Date: 28 January 2021

### **Application by London Resort Company Holdings for an Order Granting Development Consent for the London Resort**

#### **Advice following issue of decision to accept the application for examination**

Scale: **1 : 2500 @ A1** Sheet: **4 of 9** Revision: **0**

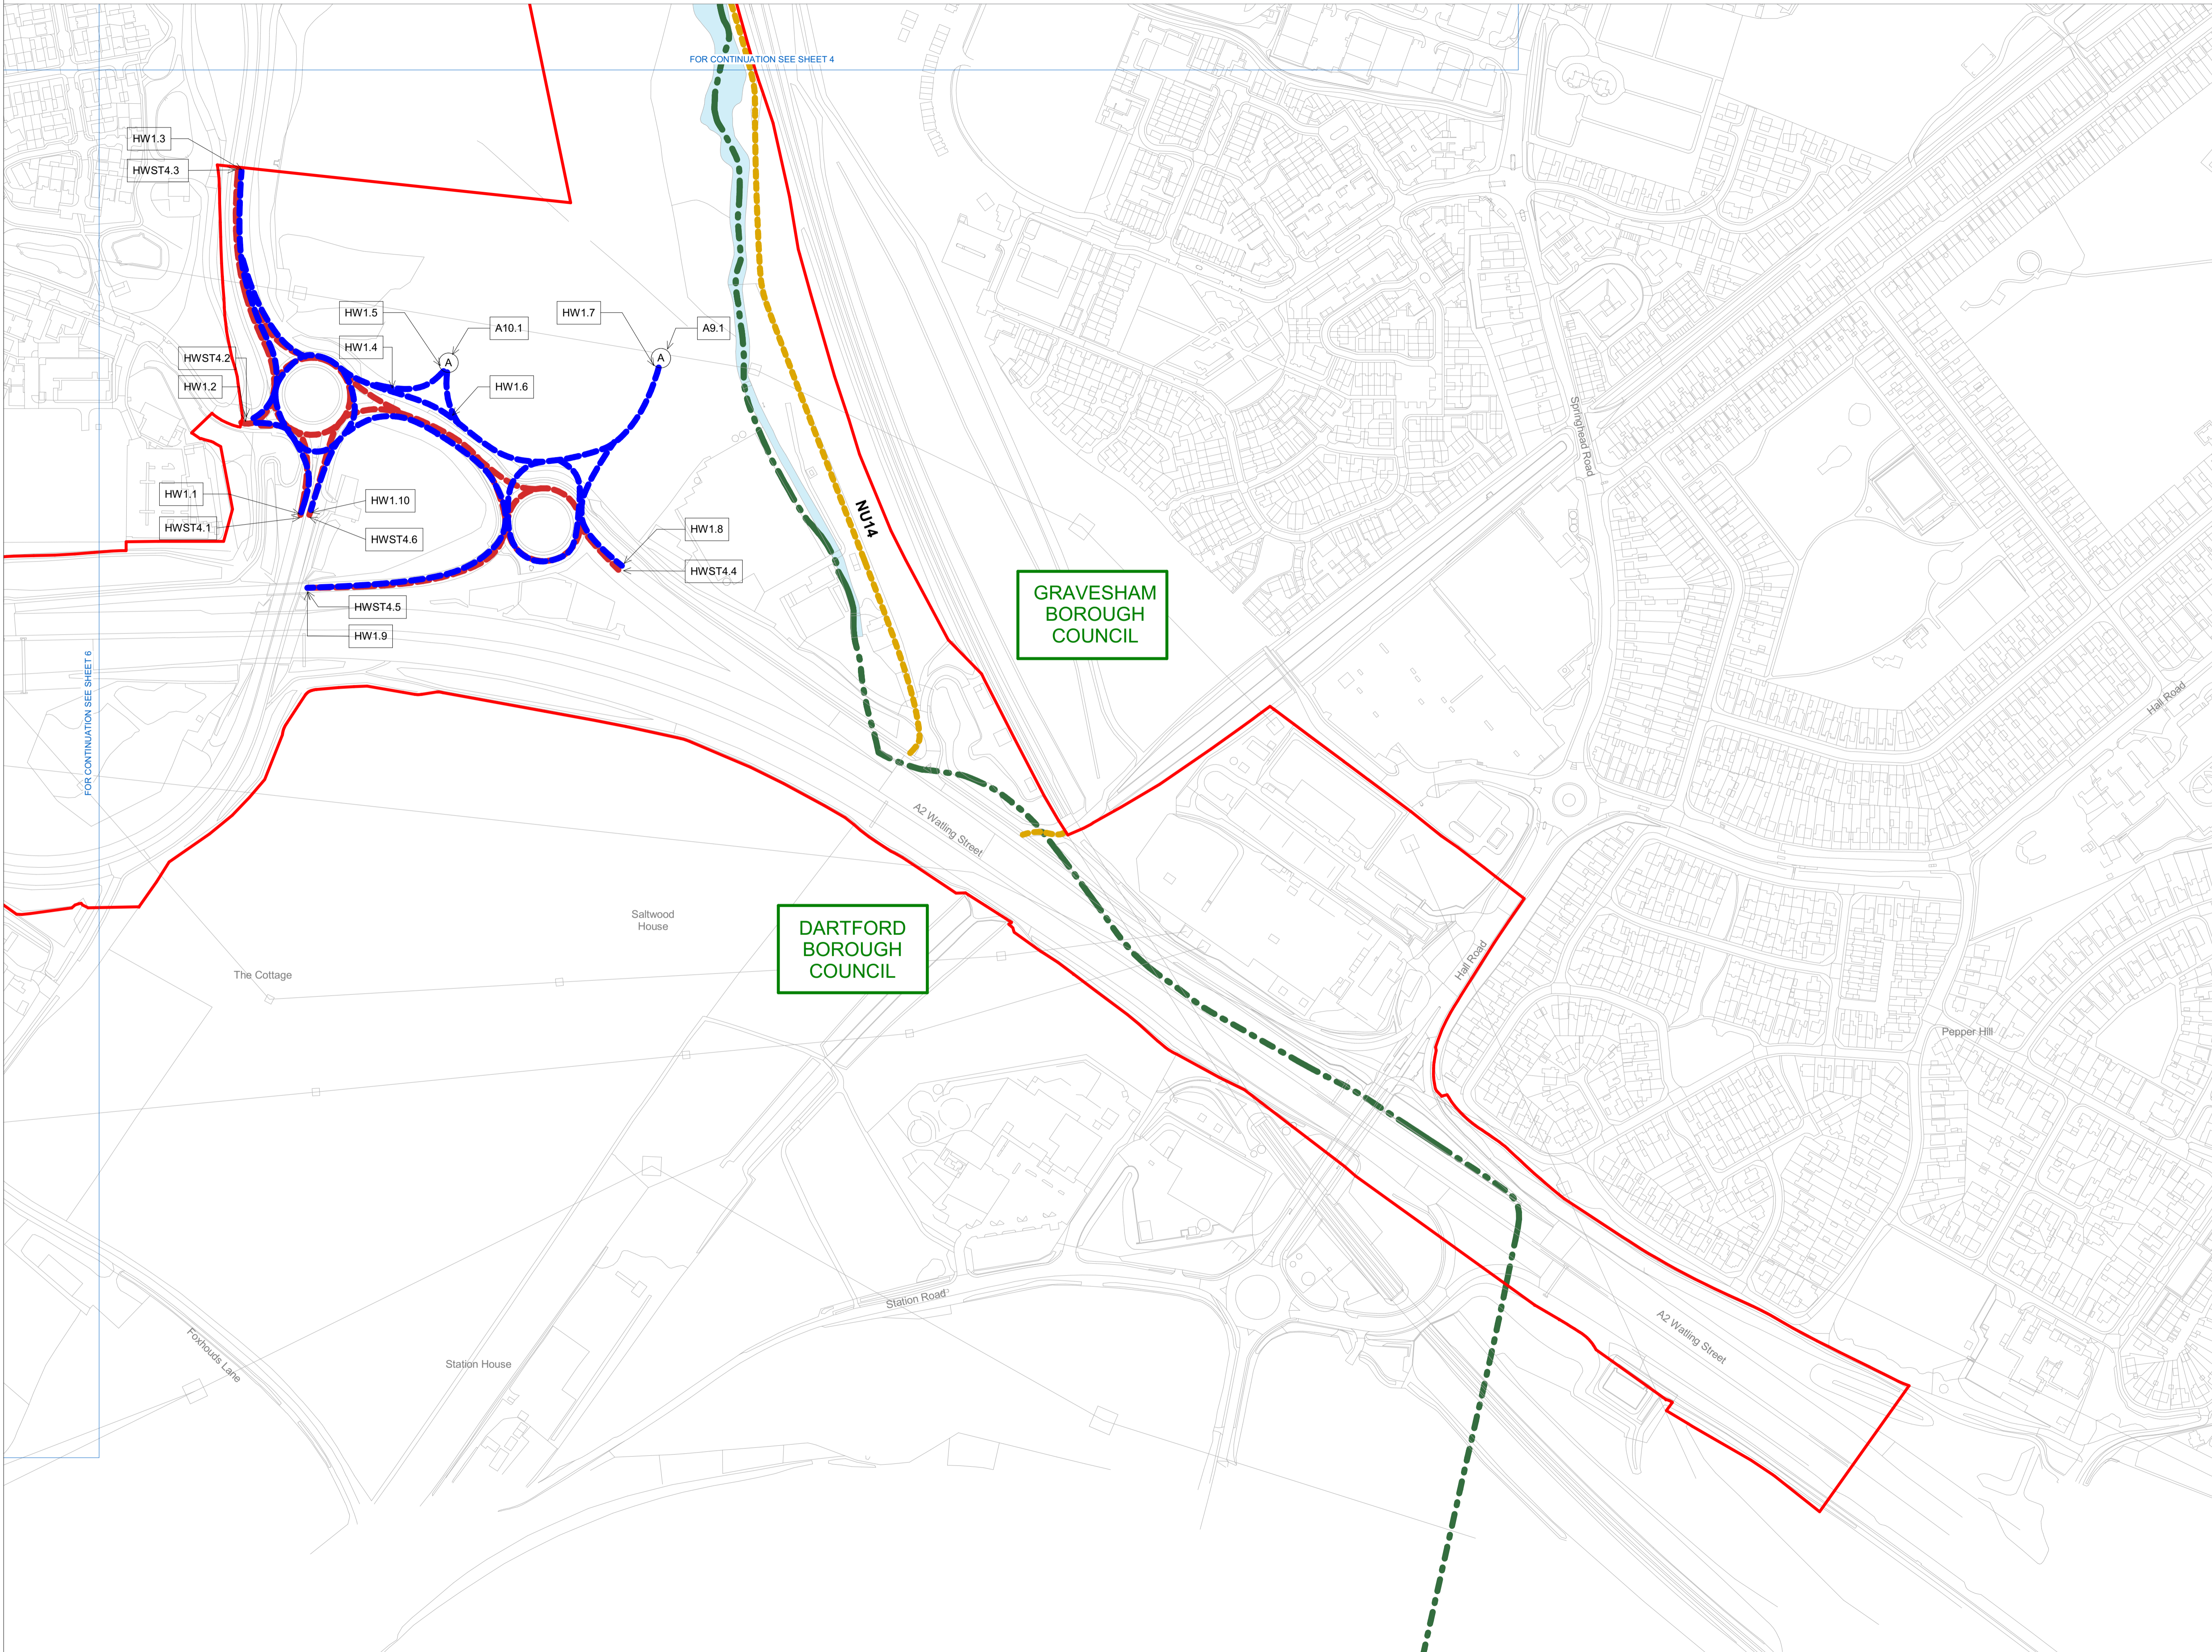
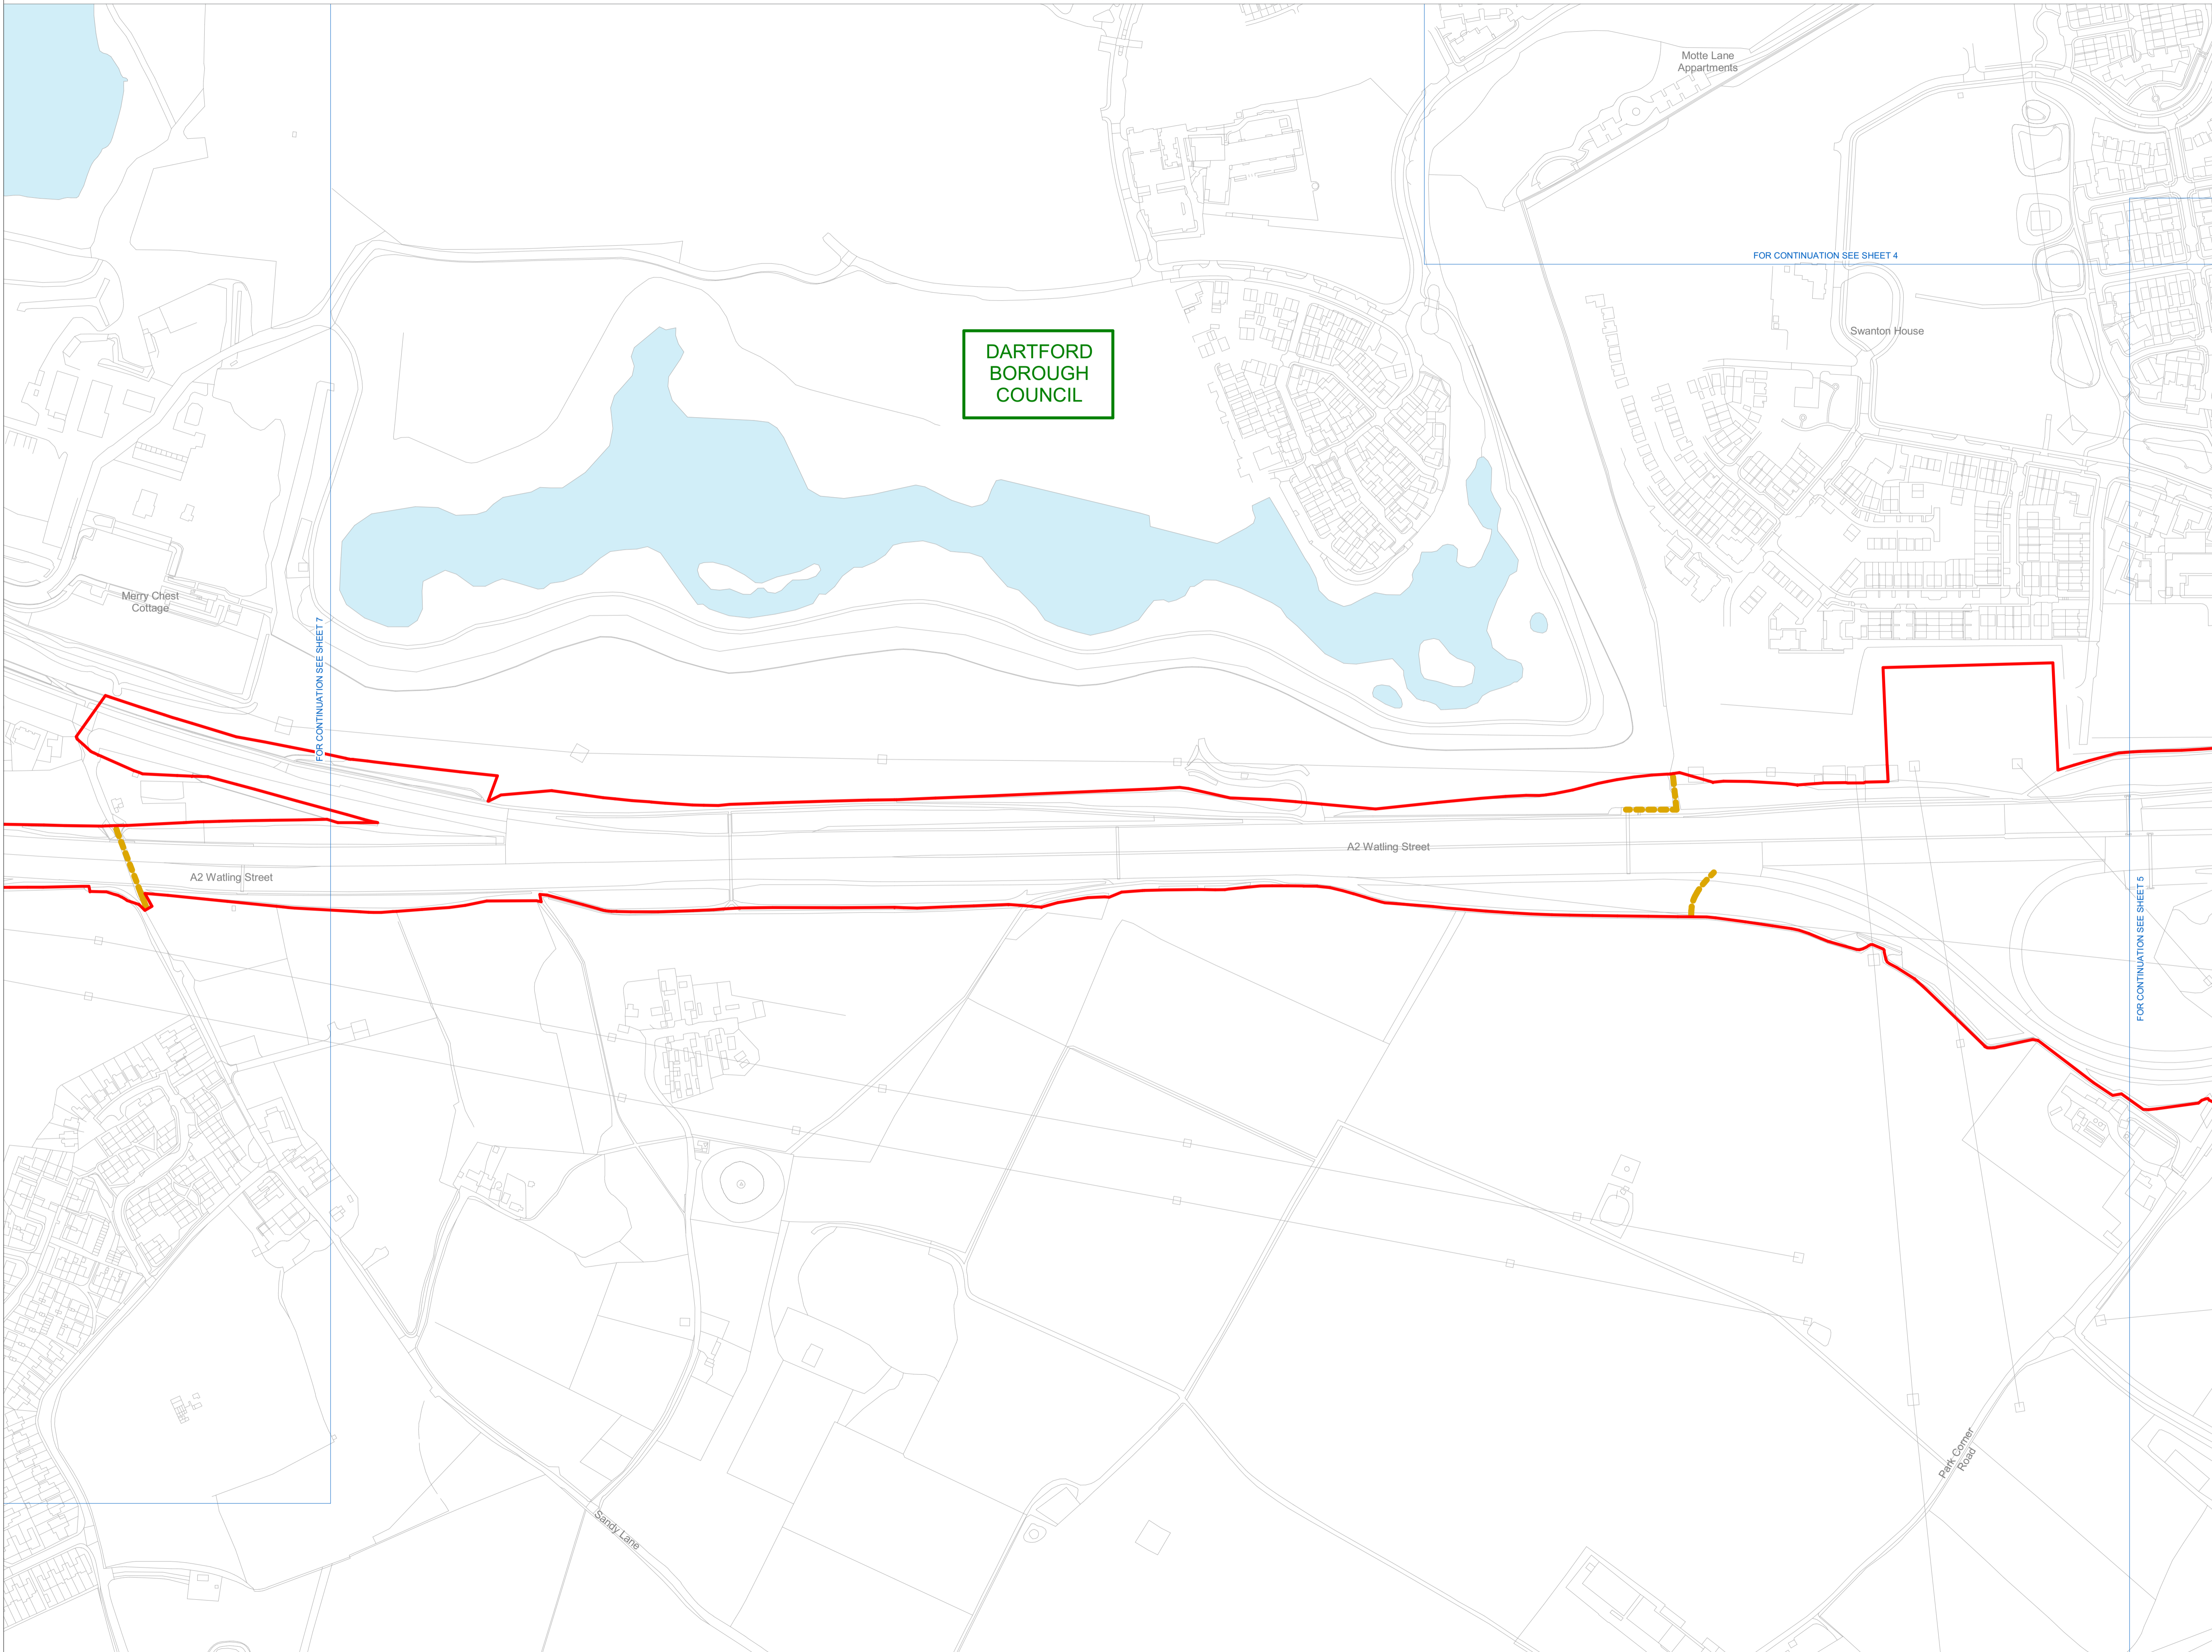
The Applicant is requested to provide updated plans which address the issues raised in Box 30 of the checklist
